Subject: FW: Planning applications 3/2012/0198 and 3/2012/0199 Backridge House, Twitter Lane, Bashall Eaves

Subject: Planning applications 3/2012/0198 and 3/2012/0199 Backridge House, Twitter Lane, Bashall Eaves

EXISTING & PROPOSED ACCESS ARRANGEMENTS

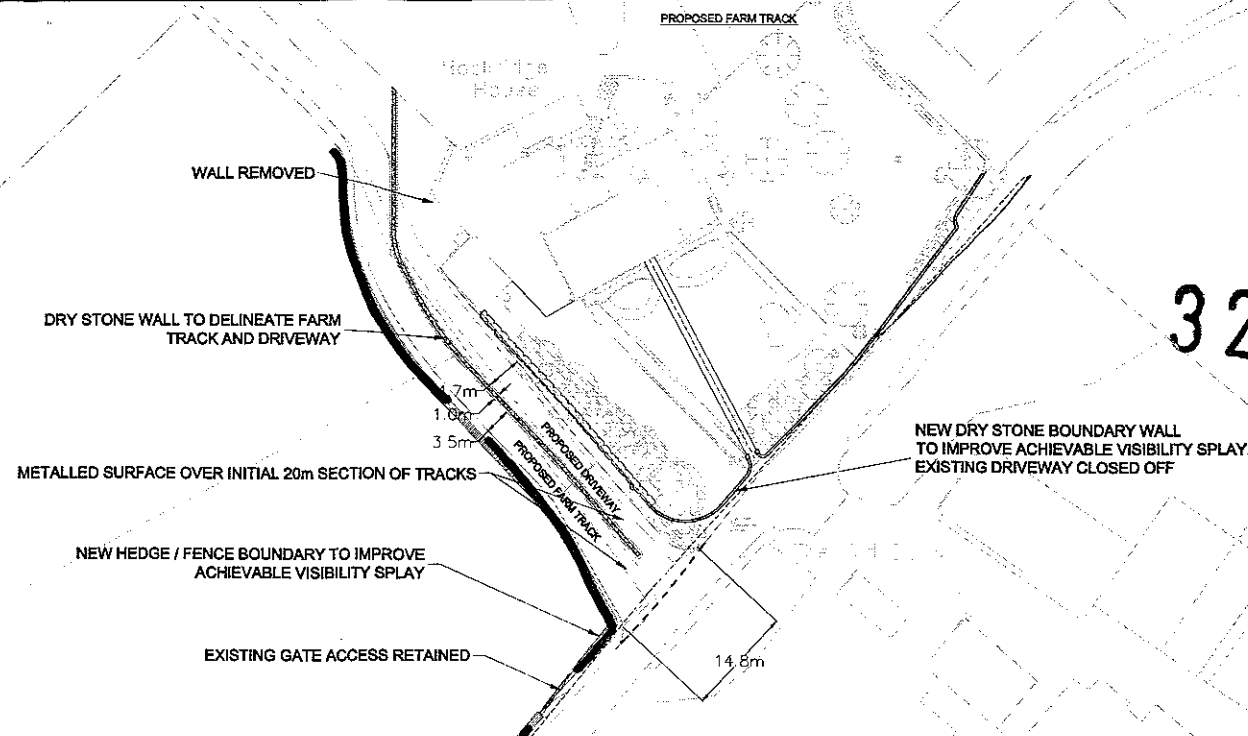
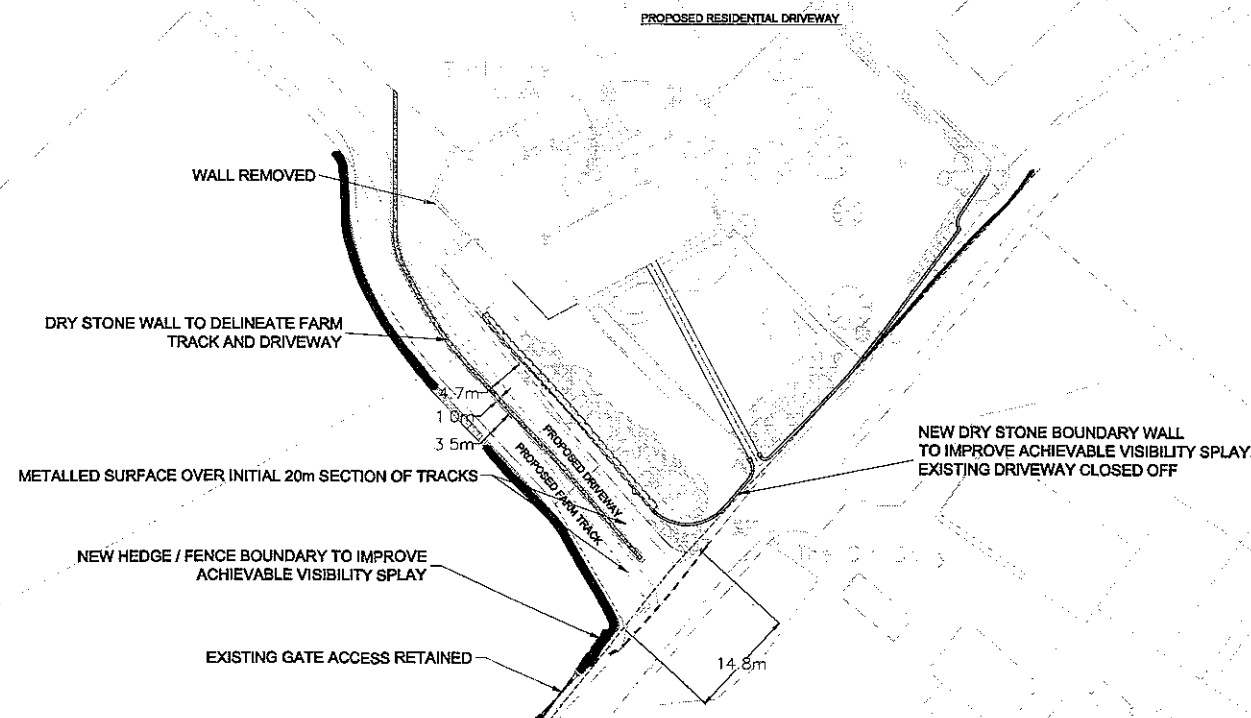
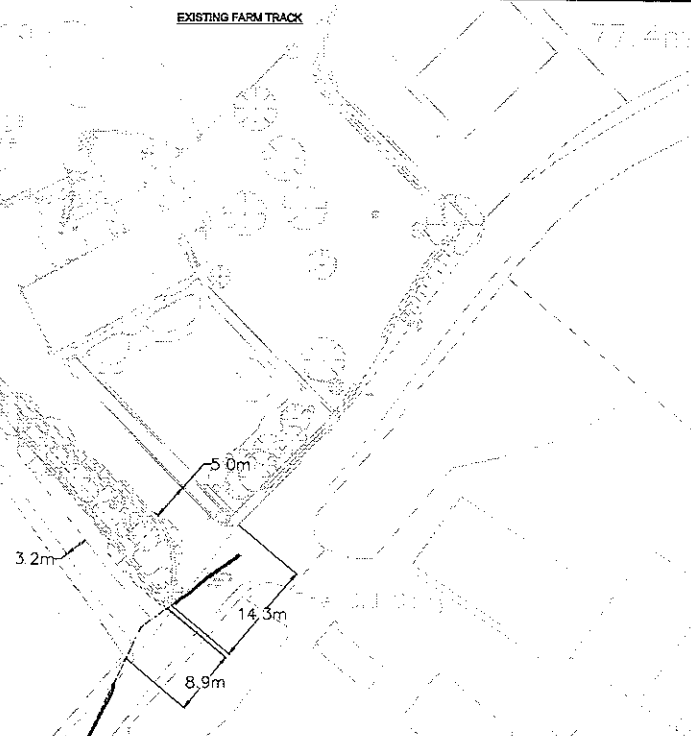
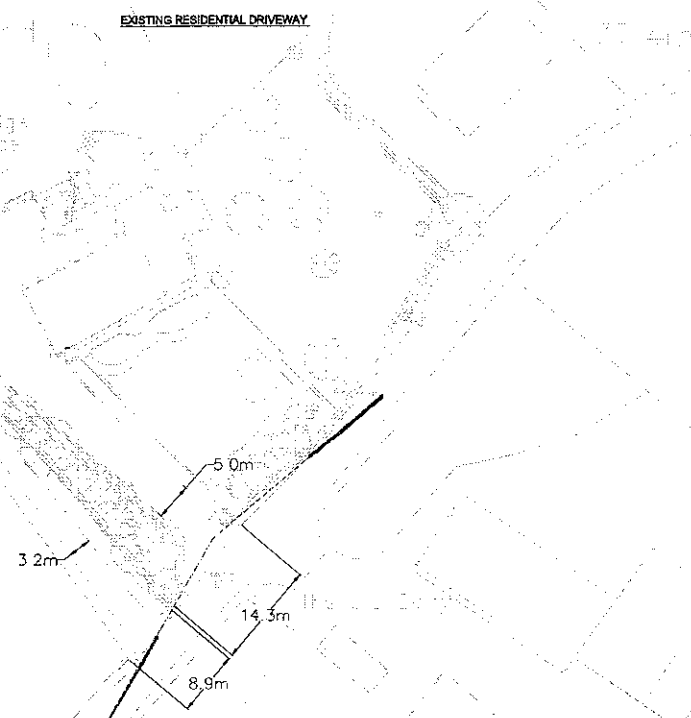
The proposed access arrangements represent a considerable improvement on the current layout and therefore I have no objection to the proposals, subject to the following conditions:

1. Any gateposts erected at the accesses shall be positioned 10 metres behind the nearside edge of the carriageway of Twitter Lane. The gates shall open away from the highway. Reason: To permit vehicles to pull clear of the carriageway when entering the site.

2. Before the accesses are used for vehicular purposes, that part of the accesses extending from the highway boundary for a minimum distance of 20 metres shall be appropriately paved in tarmac, concrete, block pavements, or other approved materials. Reason: To prevent loose surface material from being carried onto the public highway thus causing a potential source of danger to other road users.

3. The existing residential access driveway to Backridge House shall be physically and permanently closed and the verge shall be reinstated. Reason: To limit the number of access points to the highway at this location in the interests of road safety.
